EL PASO COUNTY PLANNING & COMMUNITY DEVELOPMENT  
SIGN APPLICATION

SC18057

<b>DATE:</b> _____	
<b><u>Business</u></b>  Name: <u>Glen Eagle Self Storage</u> Address: <u>13760 Sturthers</u>  Zone: _____ Legal Description: <u>Lot 2 Academy</u> <u>Village TRI #2</u>  <b><u>Type of Sign</u></b>  Illuminated: <u>Yes</u> Non-Illuminated: _____ Valuation: <u>52,561.00</u>  Storefront Length &/or Width: _____  Proposed Sign Sq. Ft. <u>121.17</u>  Existing Sign Sq. Ft. <u>0</u>  Total Sign Sq. Ft. <u>159.56</u>	<b><u>Vicinity Map</u></b> Tax Schedule # <u>7201402007</u> Please show major intersections.  
<b><u>Contractor Information</u></b> Name: <u>Schlosser Signs</u>  Address: <u>3597 Draft Horse Ct</u> <u>Loveland Co 80538</u>  Phone: <u>970-593-1334 #406</u>  Type of License: _____  Contractor ID# <u>21575</u>	<b><u>Elevation Drawing</u></b> Indicate storefront length & placement of sign.  <u>see attached</u>
<b><u>Sign Plan</u></b> (Please indicate dimensions and sign copy)  Sign B1 - 2.21/2' x 9.81/2' = 21.36sf Sign B 2 - 2.21/2 x 9.8/2' 21.36 sf Sign D - 4.8' x 8.7' = 40.06sf Sign A - 2.11 1/4' x 13. 03/4' = 38.39 sf  See attached for copy of signs

• EAST ELEVATION BUILDING A 1/8"=1'-0" •

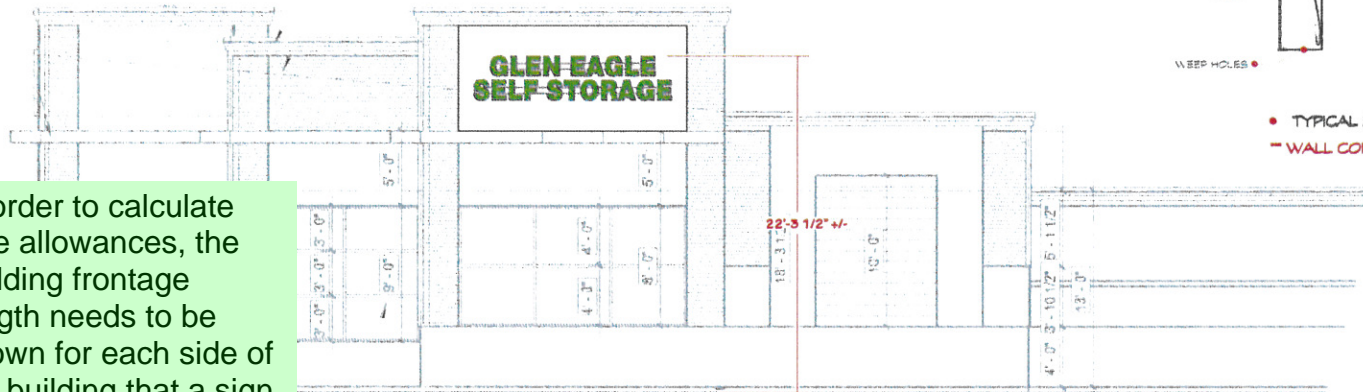
In order to calculate size allowances, the building frontage length needs to be shown for each side of the building that a sign is present

In order to calculate size allowances, the building frontage length needs to be shown for each side of the building that a sign is present

• EAST ELEVATION BUILDING C 1/8"=1'-0" •

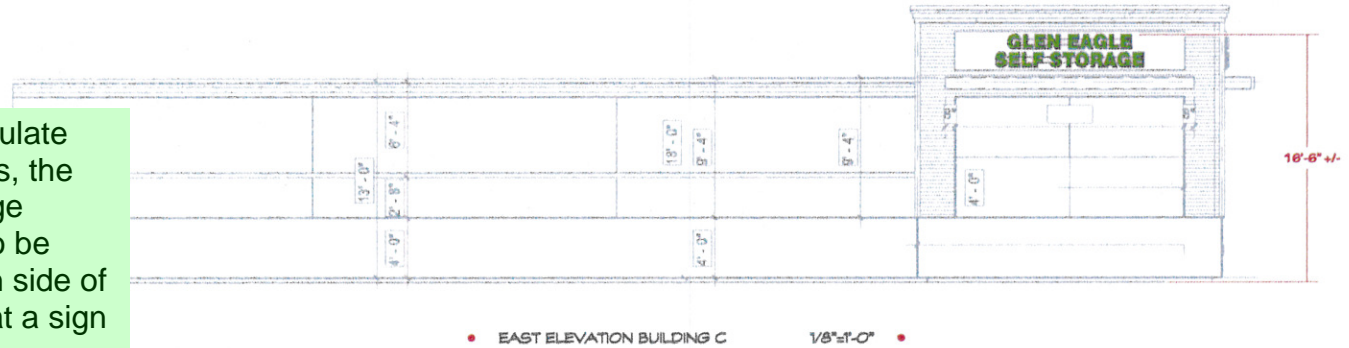
In order to calculate size allowances, the building frontage length needs to be shown for each side of the building that a sign is present

• EAST ELEVATION BUILDING B 1/8"=1'-0" •

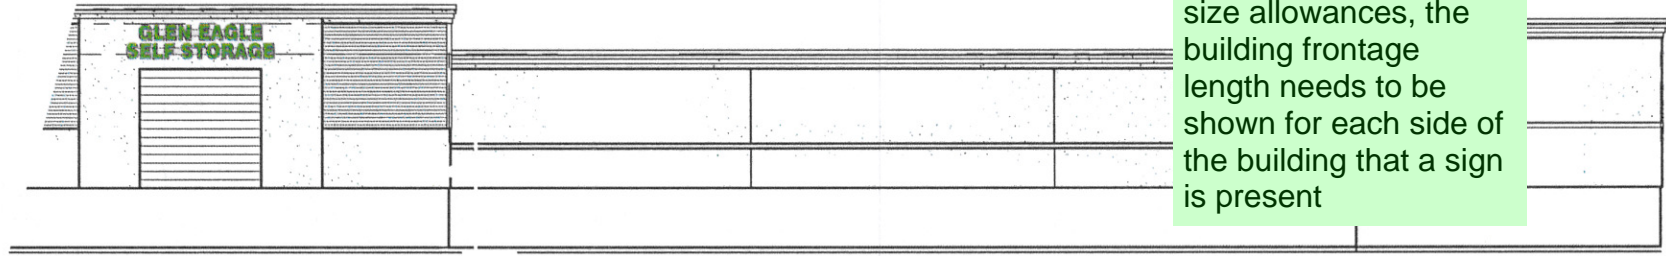
In order to calculate size allowances, the building frontage length needs to be shown for each side of the building that a sign is present
